From: Michael Eastham <Michael.Eastham@arun.gov.uk>
Sent: 04 February 2021 12:58
To: Planning.Responses <Planning.Responses@arun.gov.uk>
Subject: FW: BN/1/21/DOC - Condition 29 - the location and installation of fire hydrants: Land at Angels Nursery, Barnham

Subject: RE: BN/1/21/DOC - Condition 29 - the location and installation of fire hydrants: Land at Angels Nursery, Barnham

The details of the fire hydrants are set out on **Drawing No. MU1115-W001 Rev. 04 - Water Construction Plan**. A copy of the plan is attached to this email for ease of reference.

TITLE: **WATER CONSTRUCTION PLAN**

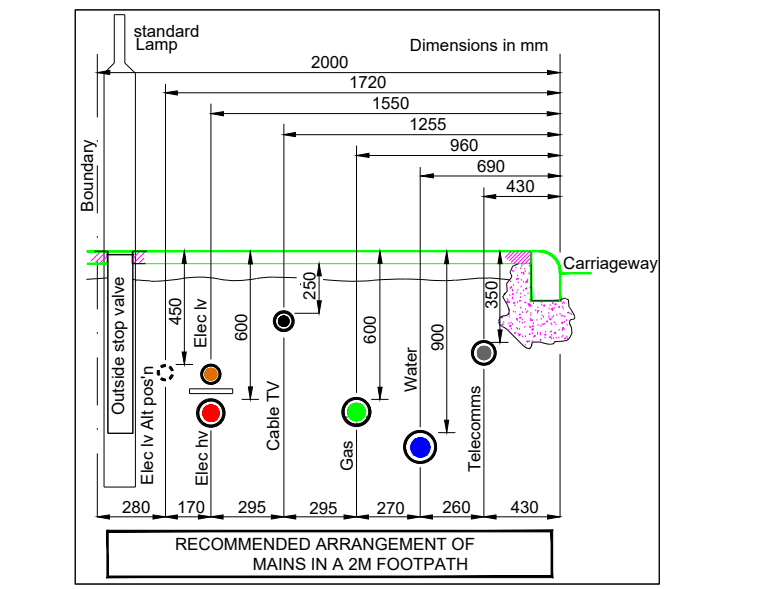
West Sussex Fire & Rescue Service only consulted on this water main plan on 13th November 2020. We can agree in principal that the plan submitted to planning is the plan we consulted with the Water company and shows the fire hydrants required positions. We have not been asked to discharge a condition so early on any previous developments, particularly on a scheme where the water main has not yet been laid.

West Sussex Fire & Rescue Service do not discharge a fire hydrant condition until we know the fire hydrants are installed in the right position, sighted, tested and fit for purpose. We have been caught out in the past with developments being completed, occupied and no fire hydrants provided. So until the above has been achieved we would not discharge the condition.

When we inspect the site prior to its occupation the fire hydrants are checked to ensure they are in the right location, not wrongly positioned (as we have found on several occasions). We then check they are suitable for use, fit a standpipe and turn key, operate the hydrant, pressure test it and make sure it is fully operational. It is then plotted on our operational mapping system showing it is available to Fire Crews when attending a fire. Until this is carried out, we would not be in a position to discharge a condition.
